From: Charlotte Hardy
Sent: 02 October 2017 17:34
To: [REDACTED]
Cc: Michael Eastham; [REDACTED]
Subject: FRA v4 for BE/102/17/OUT

The main points were that as it is not purely an outline application being dealt with but a hybrid one, essentially the groundworks including the SUDS (detention basins/attenuation ponds), the village buffer, landscaping and a building would be approved. As such we will need some more detail to be provided for us to be satisfied in terms of the flood risk side, which as mentioned Michael will then need to reconsult with the necessary people for their views. Specifically, this starts with:

SALTBOX SITE – BOGNOR REGIS

FLOOD RISK ASSESSMENT

Project	Originator	Zone	Level	Type	Role	Number
6090	KSA	ZO	XX	DR	C	6000

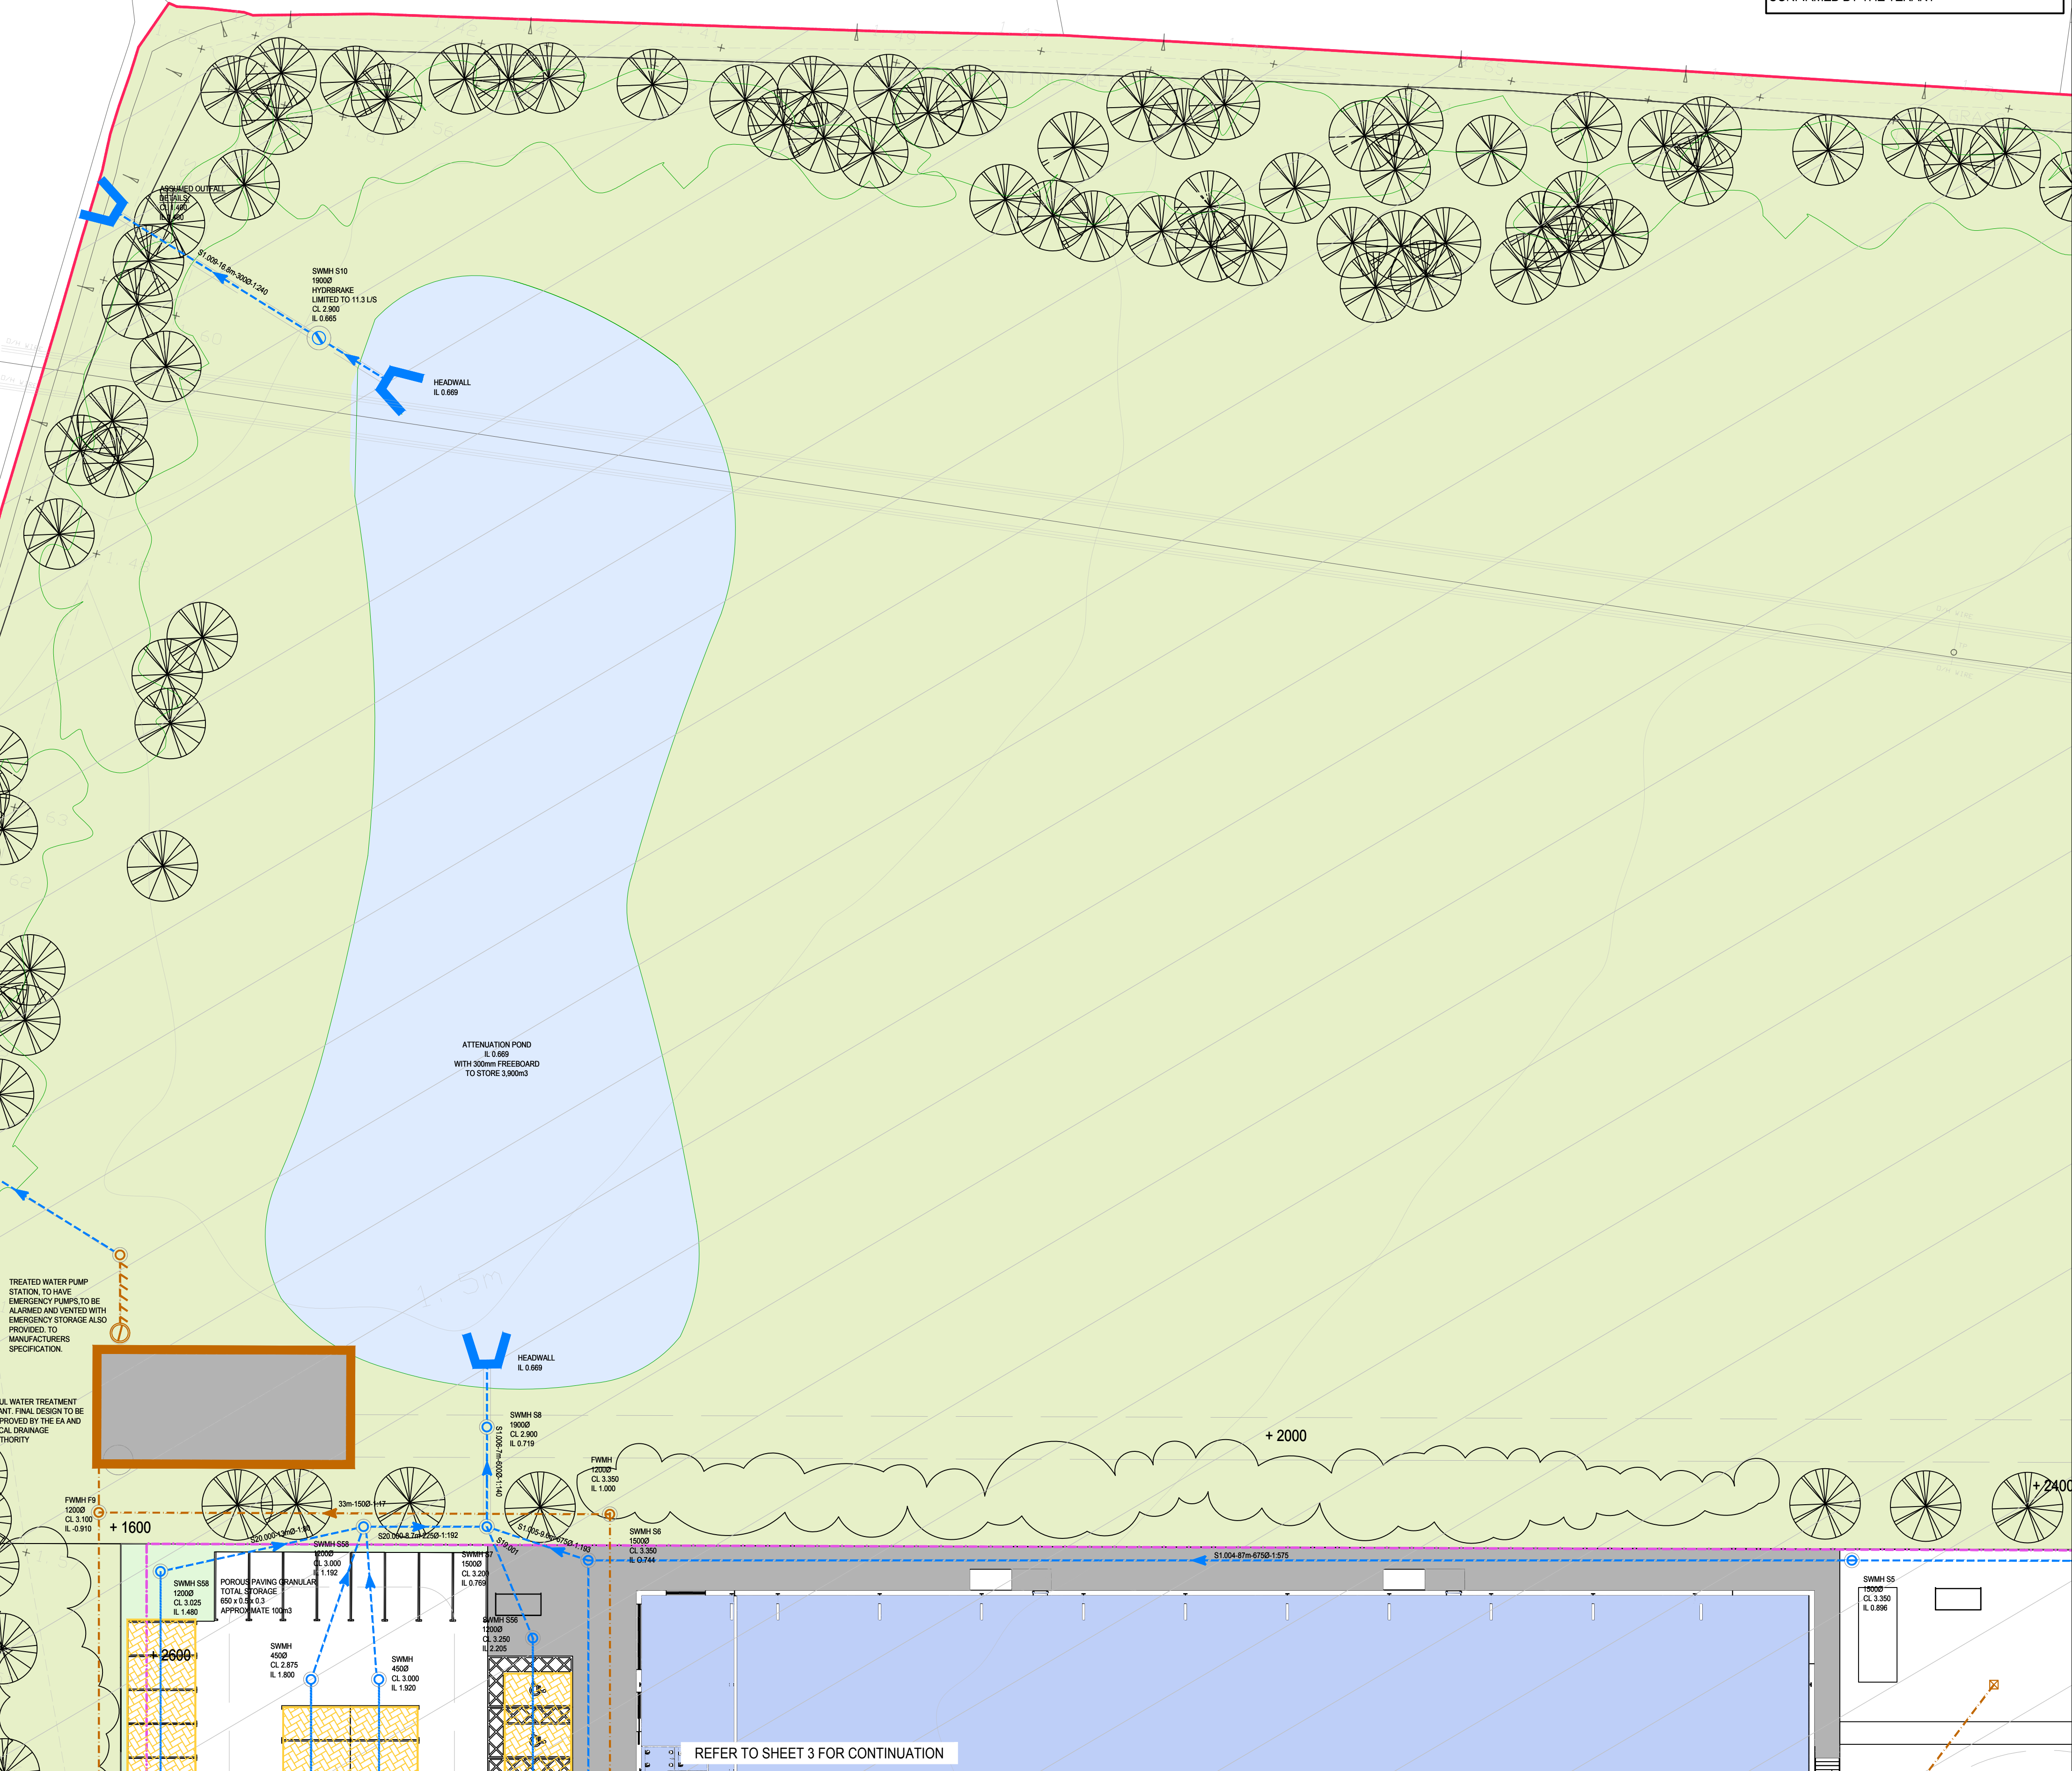
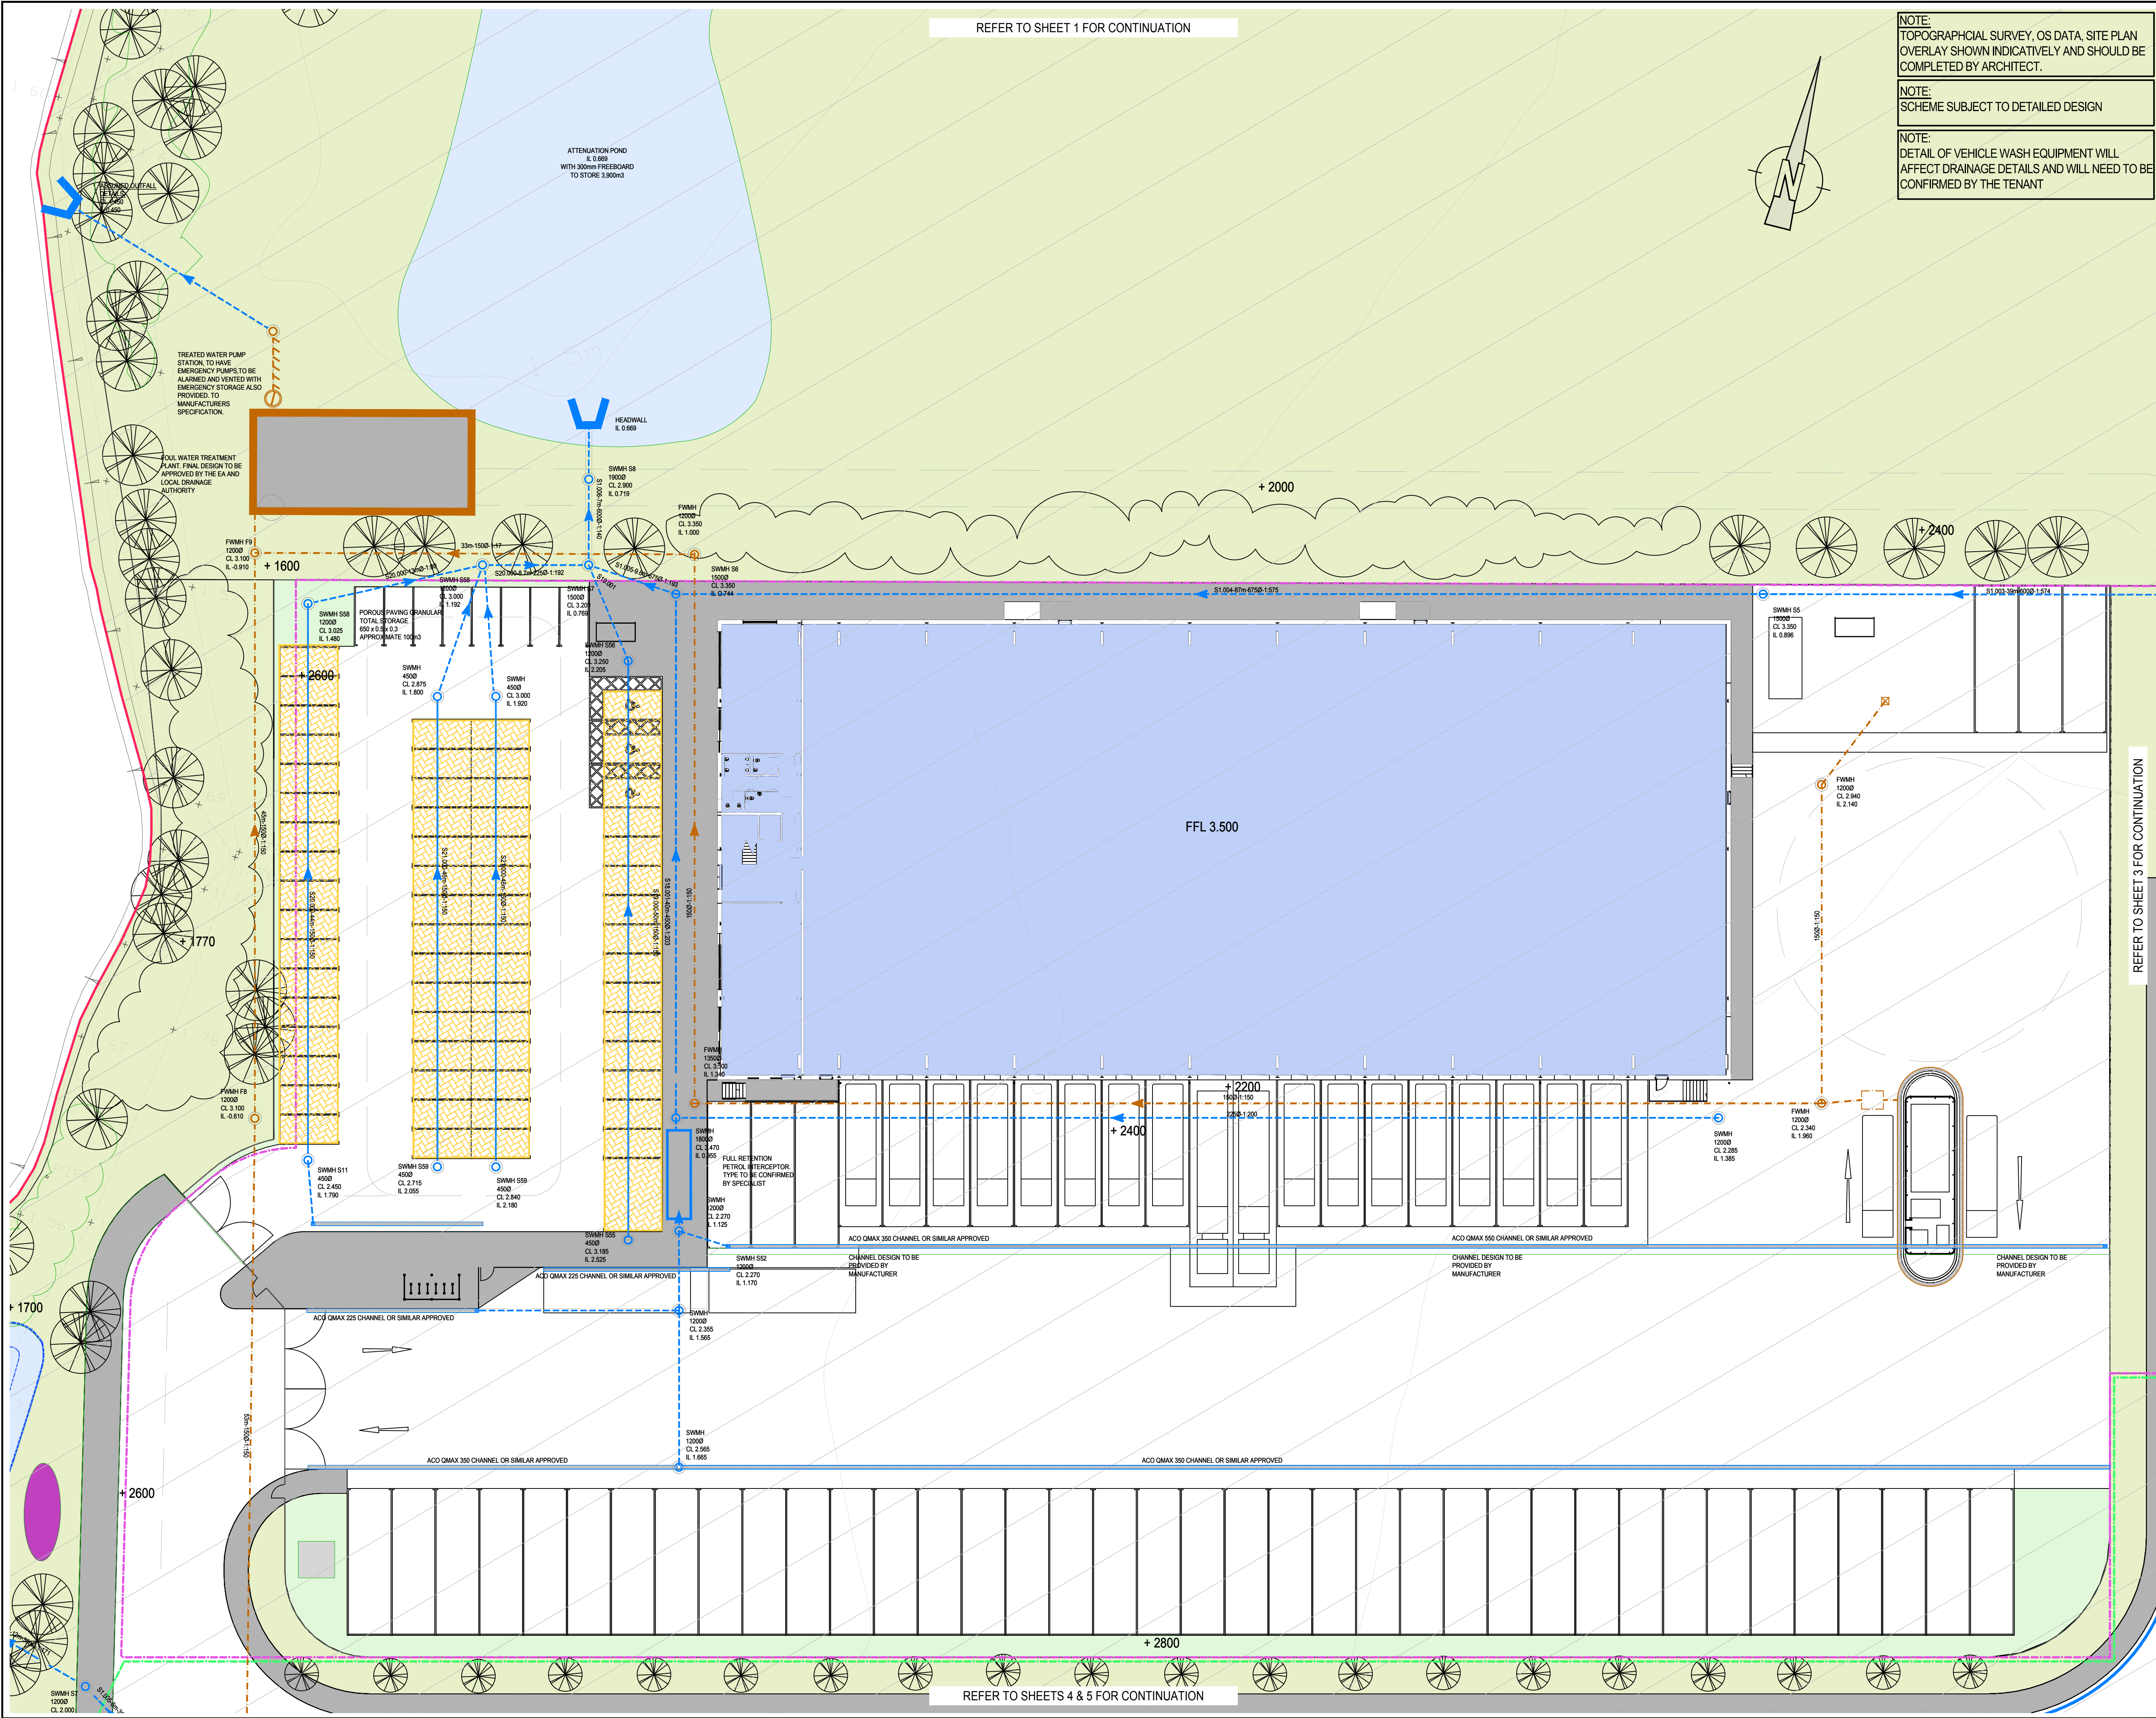
1. Information relating to the groundwater levels across the site
2. The treatment plant, along with the expected connections
3. The survey work of the watercourse and details, for certainty to be gained over the achievability of the gravity connection
4. The achievability of delivering the detention basin as shown in the buffer area considering SSEs plans for the pylons.
